CITY OF ALBUQUERQUE

September 30, 2022

**RE: Curia Building Addition
34401 Alexander Blvd. NE Albuquerque, NM 87107
Grading and Drainage Plan (F16D003B1)
Engineers Stamp Date 9/2/2022**

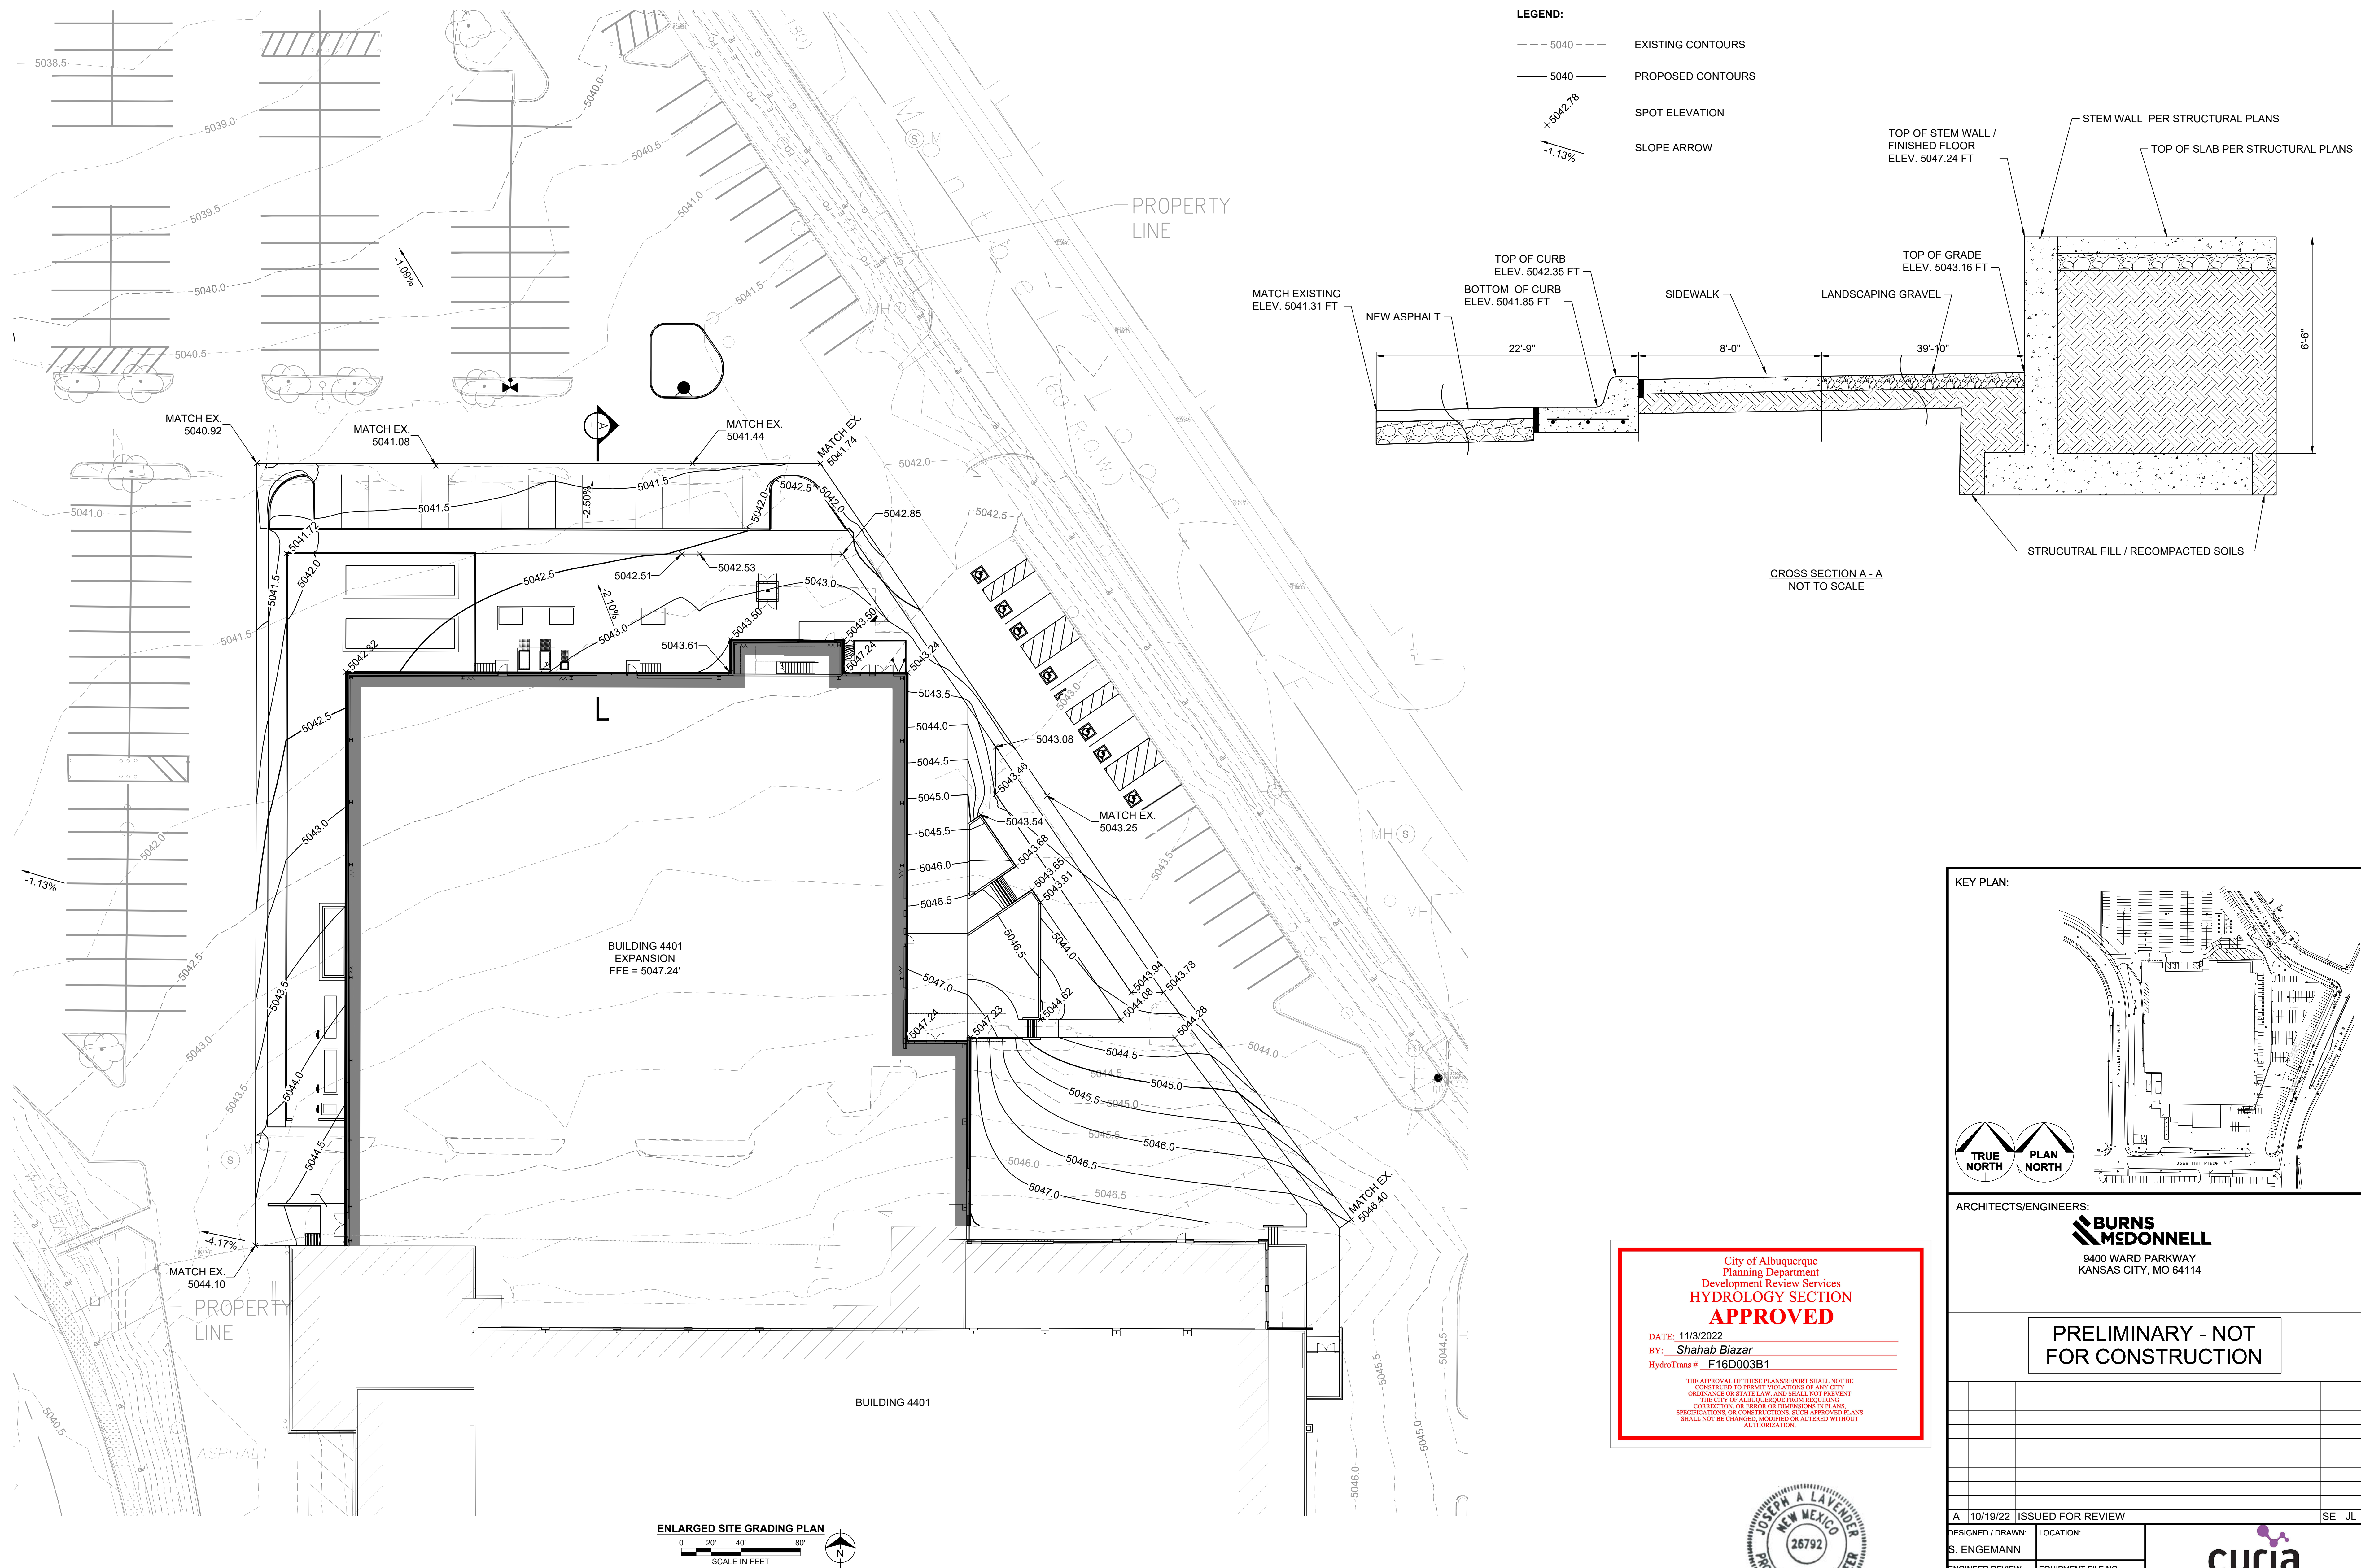
- 1) This site is under runoff discharge restriction of 0.10 cfs/acre.
- 2) All runoff from this site must be routed through the existing detention pond. The detention pond must be analyzed to ensure it does not exceed the allowable discharge.

- 3) Part of the site appears to drain to Montbel Loop via a concrete rundown. This may be allowed if the overall discharge from the site does not exceed the allowable discharge.

- 4) Provide detail elevation and finished contours around the building and beyond to show how it will tie to the existing grades. To the north the Finished Floor elevation is nearly 6' about the exiting grade. Are there going to be stem walls. Provide cross-sections.

- 5) First Flush Volume requirement calculations must be provided. How will the first flush volume requirement be handled?
- 6) If the existing pond is going to be modified a new Pond Maintenance & Covenant must be provided. Since most of the existing pond falls within the adjacent site, is there an existing pond easement to allow this site drains to it.
